80 Farragut St.

Fill Permit

RE: Fill Permit Application, 80 Farragut Street
(#2004-0001) (CBL 339J021)

From: Jay Reynolds
To: "SteveS@stgermain.com"@Portland.gwgewia
Date: Mon, Dec 29, 2003 9:19 AM
Subject: 80 Farragut Street Fill Permit

JOB#	00000	DATE:	09-01-01	SCALE:	1"=20'
BOOK#	770	PREPARED BY STEPHEN M SELLECK

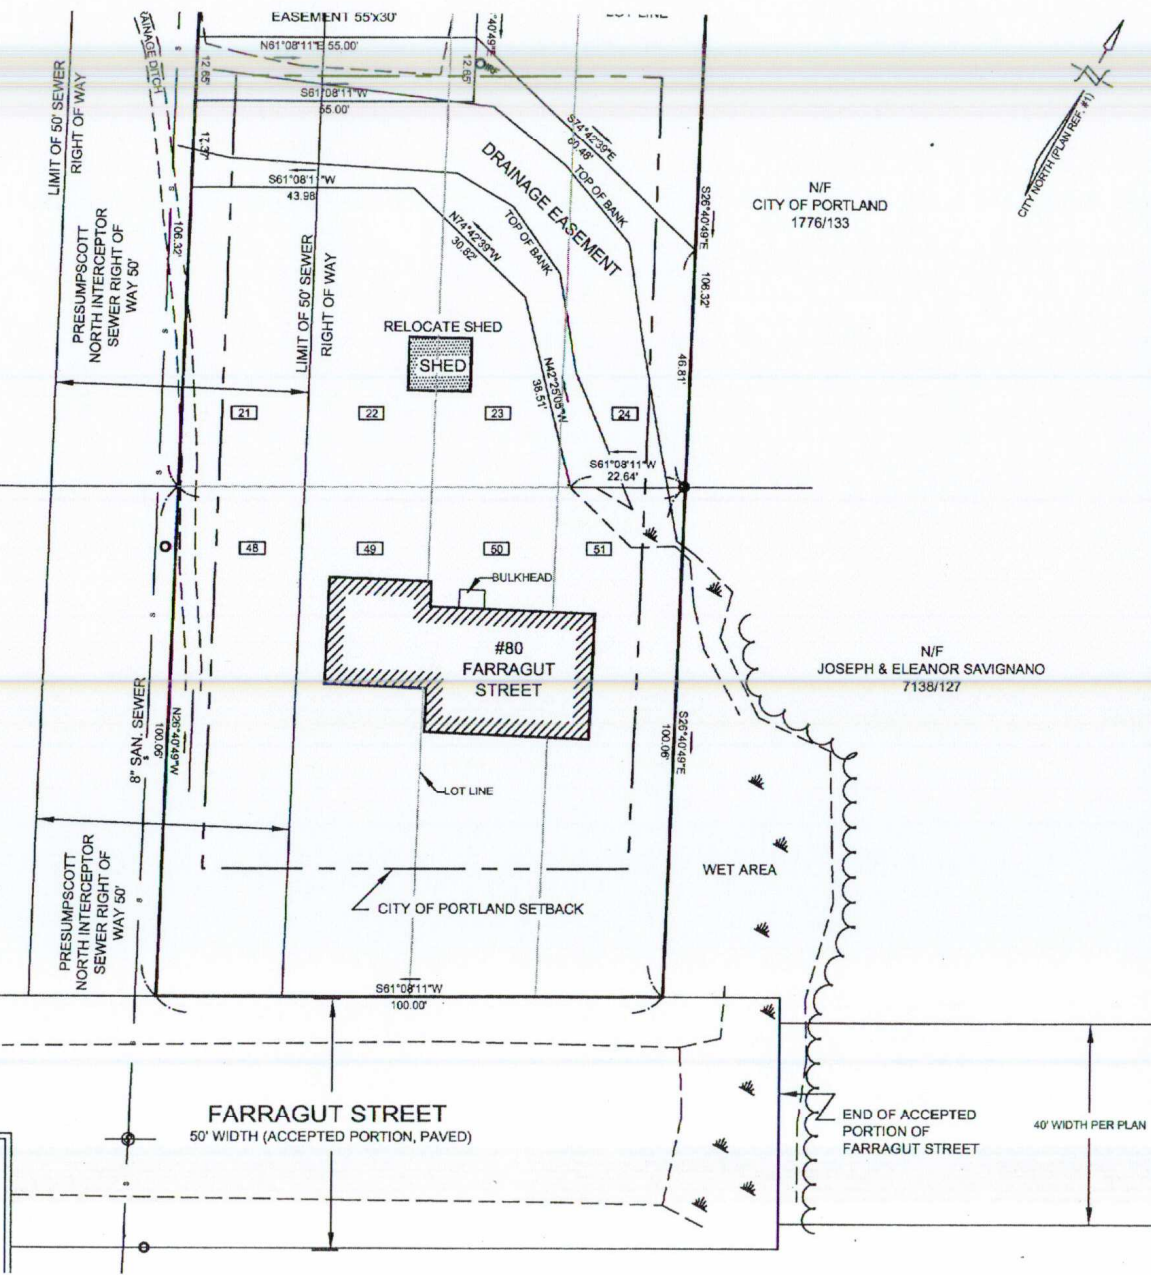
1. Filling of the swale is acceptable to the City with the following condition:

A. the swale will need to maintain a positive slope (towards the larger swale) in order to continue conveying any sheet runoff that it may collect (that runs off the City owned parcels adjacent to your lot).

B. It is the City's intent to keep this easement in place, in the event it is needed in the future. Please provide a copy of the written description of such easement (within deed).

1. *Prior to soil disturbance, erosion control measures shall be installed using best management practices.*
2. *A copy of the deed containing a written description of the easement shall be submitted to the City.*
3. *The swale shall maintain a positive slope in order to convey any sheet runoff it may collect.*
